V5_Civil CDs_comments.pdf Markup Summary

CARUBIA PROPERTIES - GRADING AND EROSION CONTROL SITE DEVELOPMENT CONSTRUCTION PLANS

LOT 2, BENT GRASS EAST COMMERCIAL FILING NO. 4

PPR256

DATE: JULY 11, 2025
SCALE: AS INDICATED
DRAWN BY: JWD
CHECKED BY: JWD
PROJECT NUMBER: 2024-019
SHEET: C5.13
UIA - RPA EXHIBIT

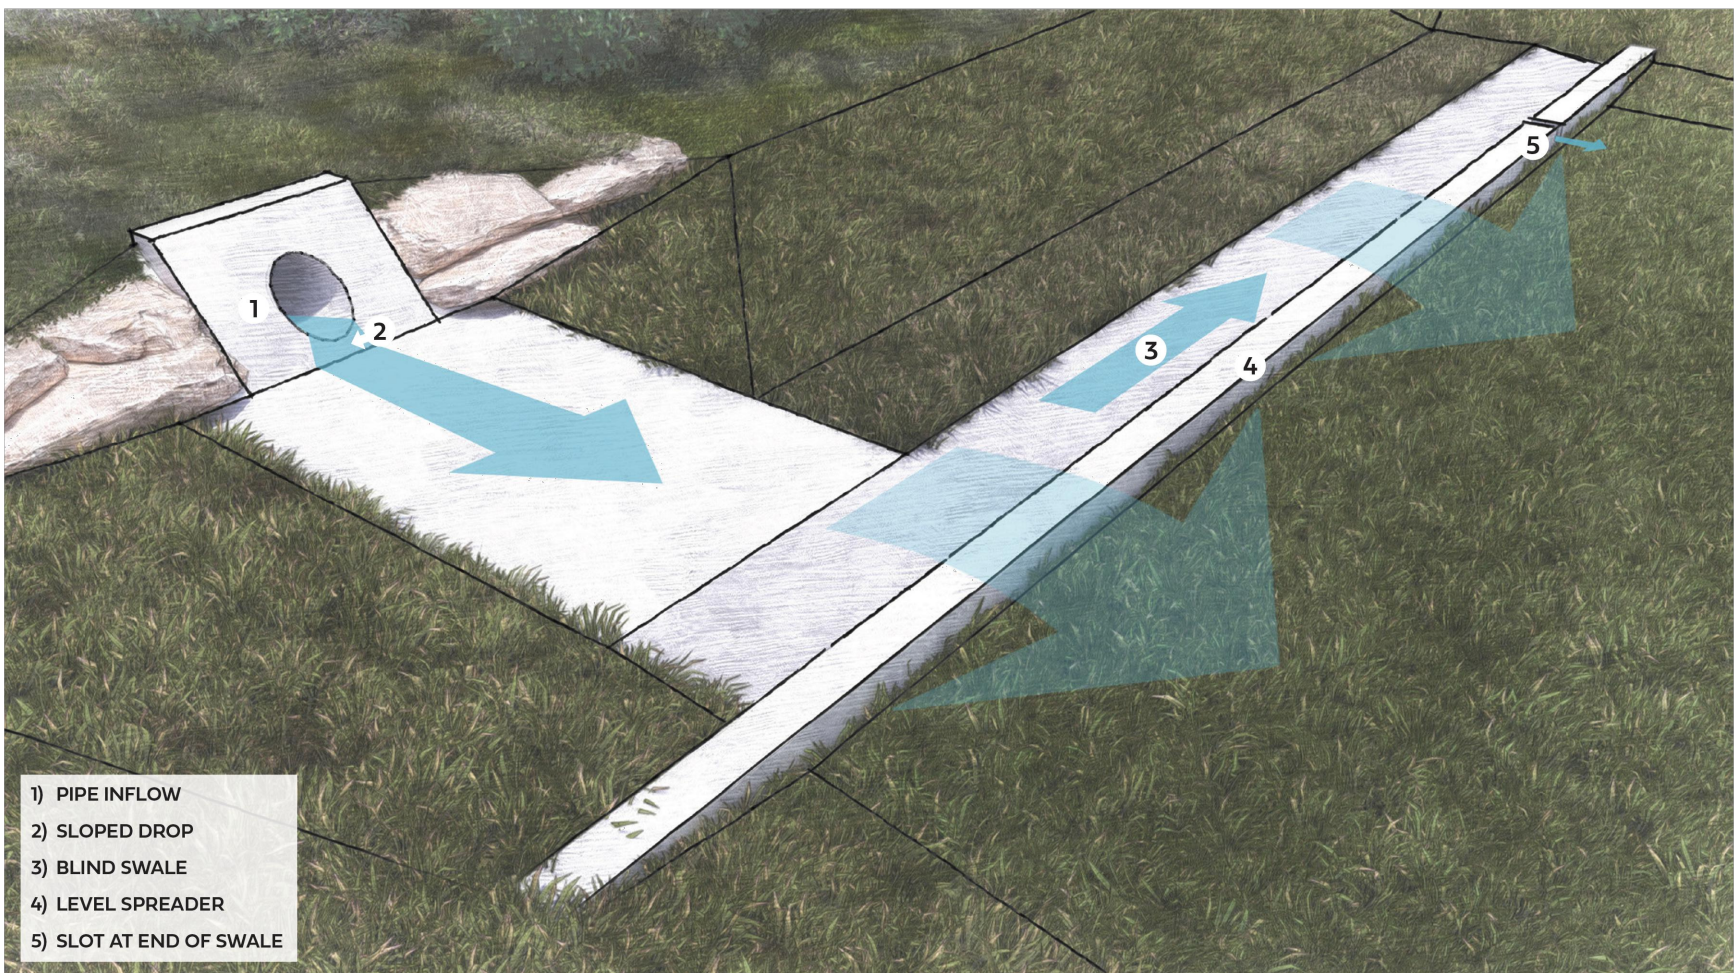
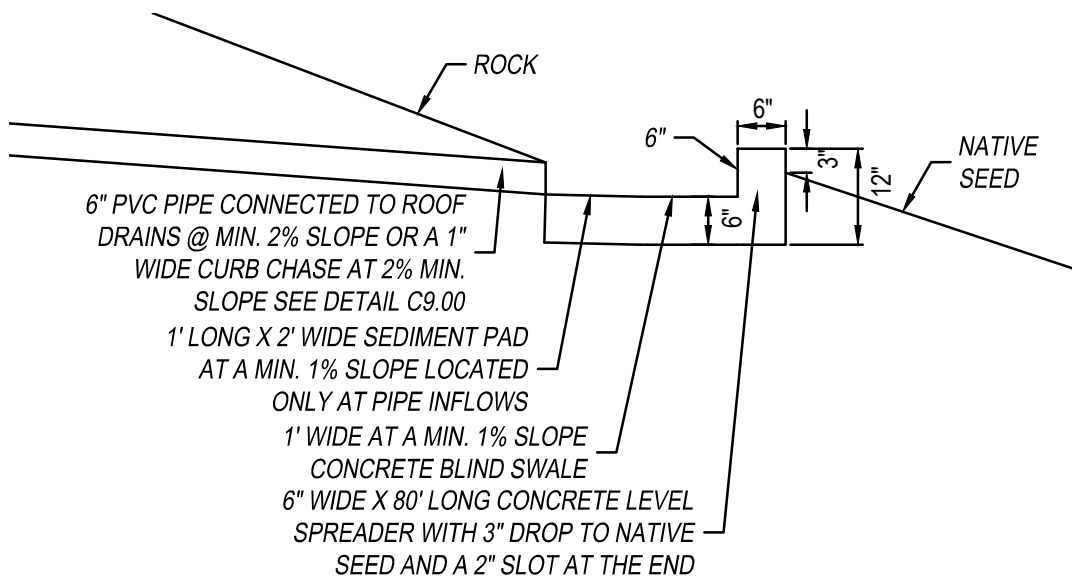
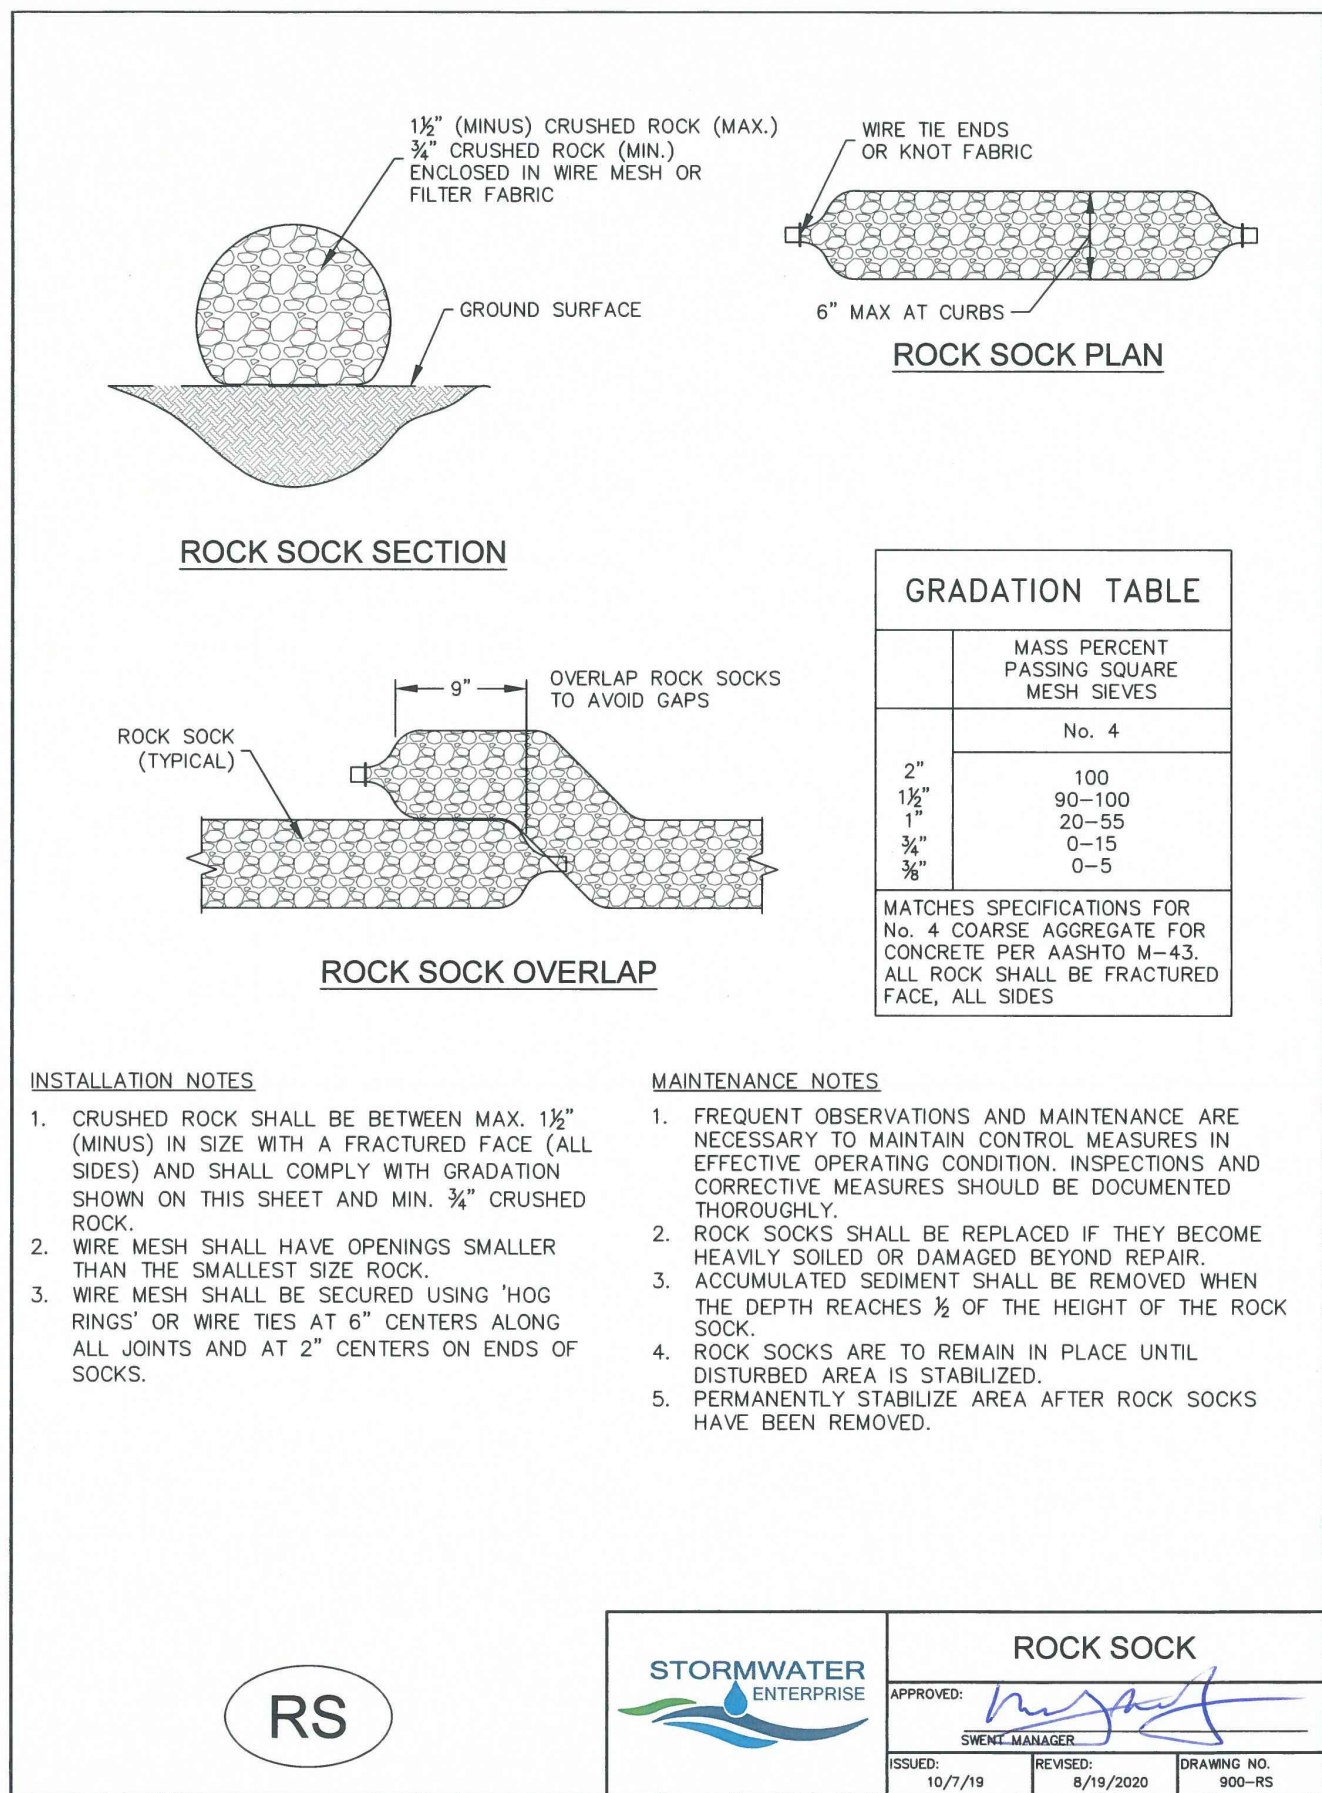
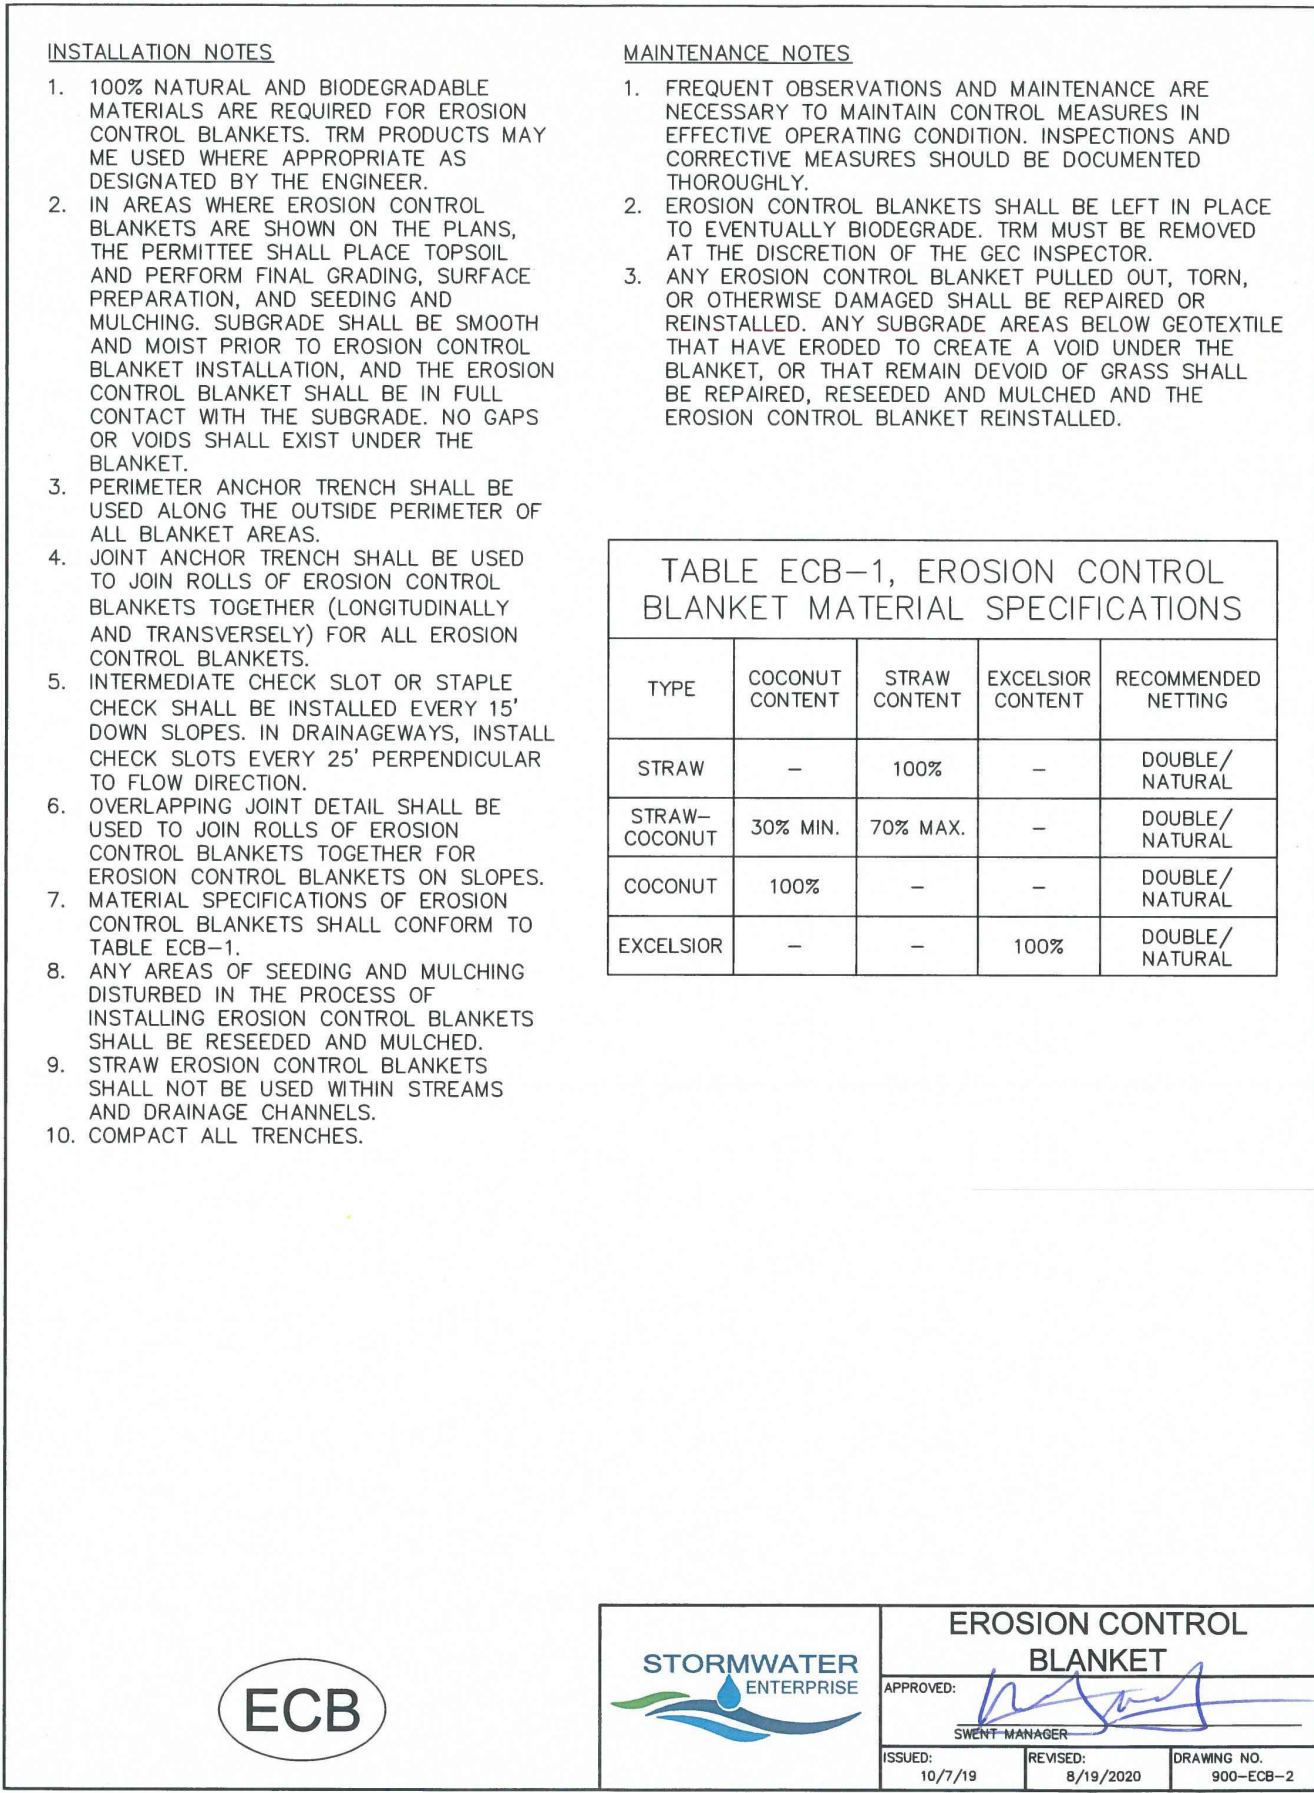
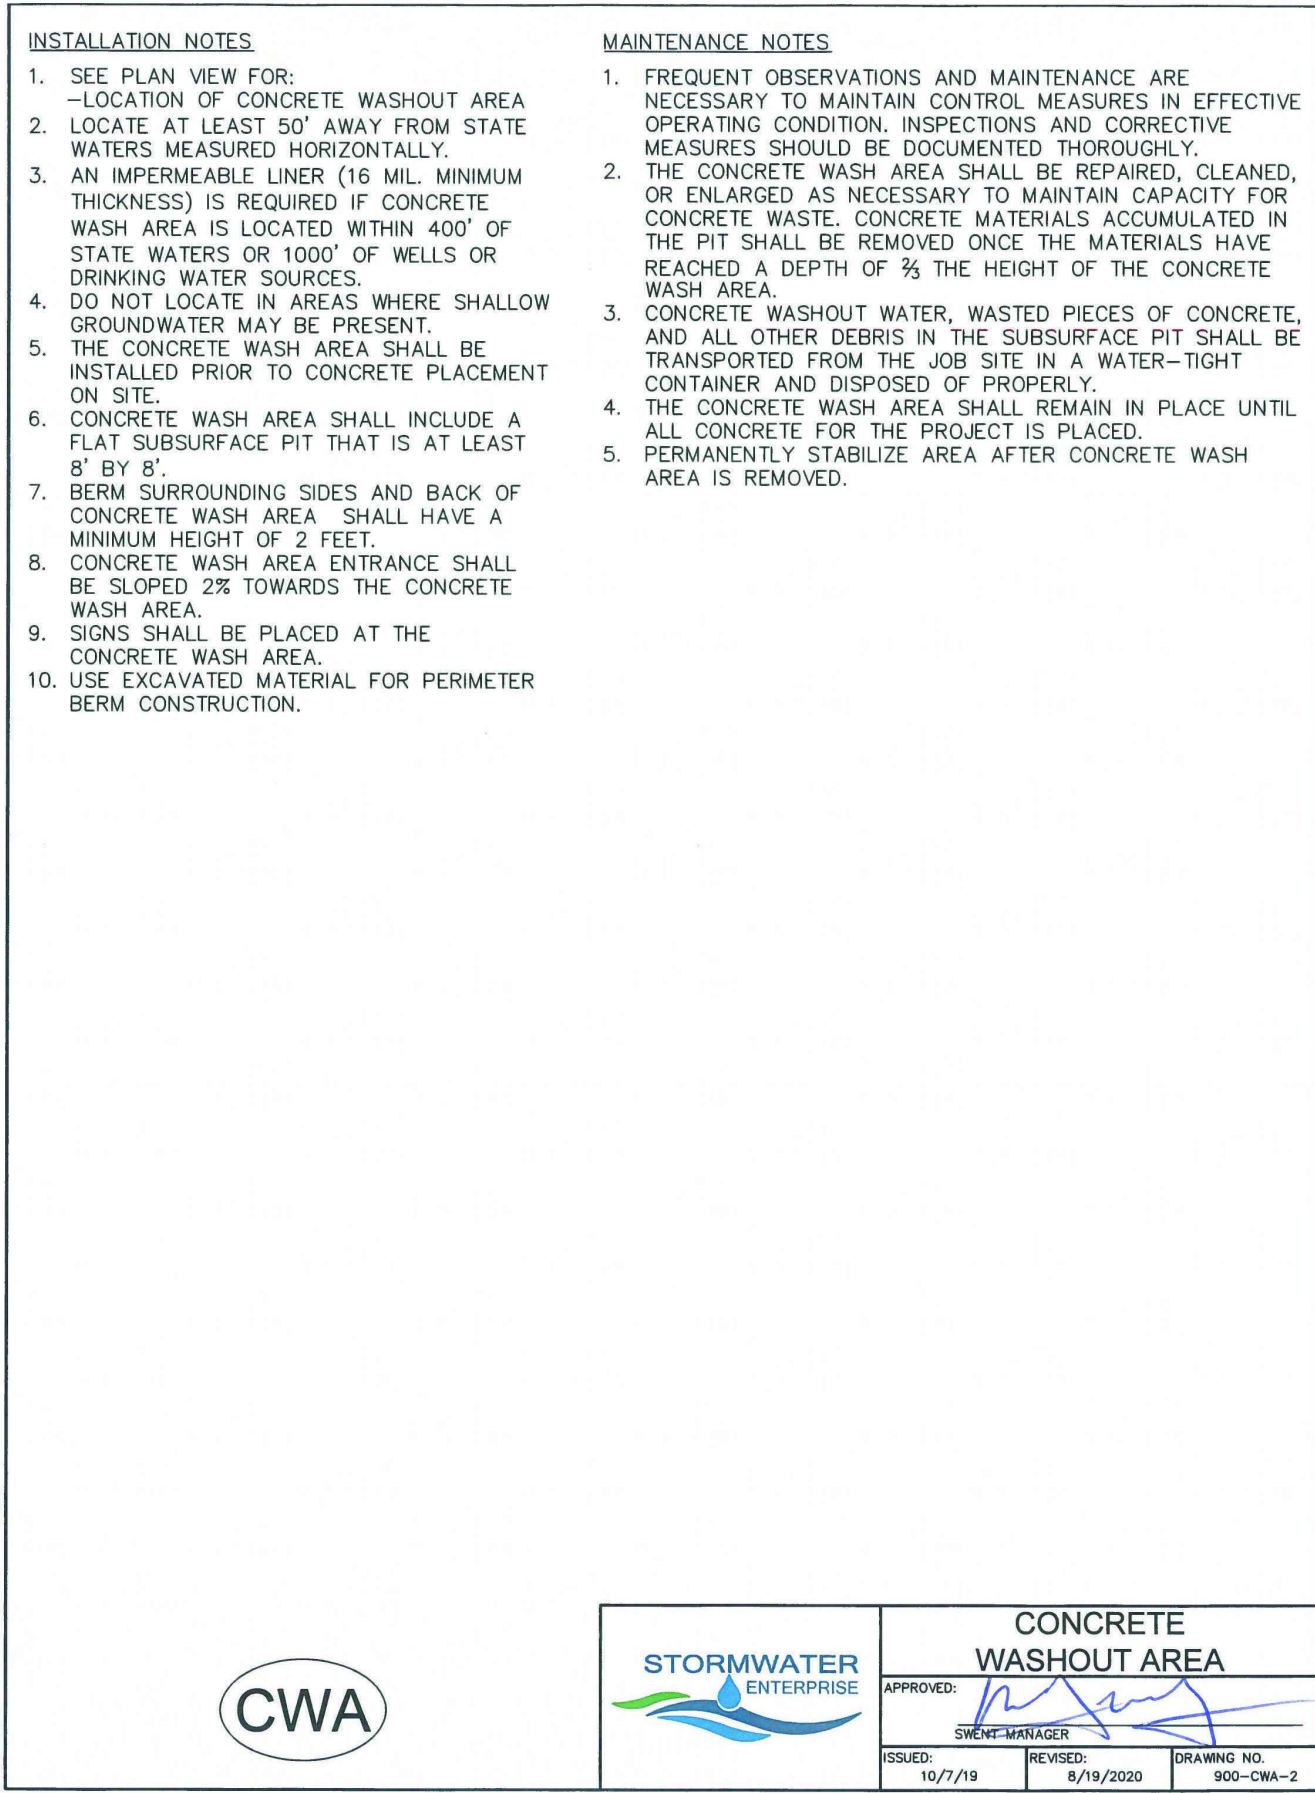
How this plan view, revise shape of both grass swales and inflows (and lack of level spreaders) per all my comments in the MHFD calcs in the Drainage Letter.

This SPA was appropriately shaded in pink with the last submittal. What happened? Please rectify.

Per the MHFD recommendation in the spreadsheet comment for this row, 2ft spacing on center is recommended.

You inputted 1' openings in the MHFD calcs. Revise to remove discrepancy. MHFD rec's 1.5' opening to protect from snow plow damage

MHFD recommends this be a vertical drop. In this case, there is high potential that the interface between the pavement/curb and the rock would get backed up with debris along the rock. With a vertical drop, this risk is much lower.

since inflows are via roof drains, they should be shown on this section.

revise inflows as needed per my comments in the MHFD calcs in the Drainage Letter.

Per MHFD guidance, Grass Swales are to be trapezoidal shaped.
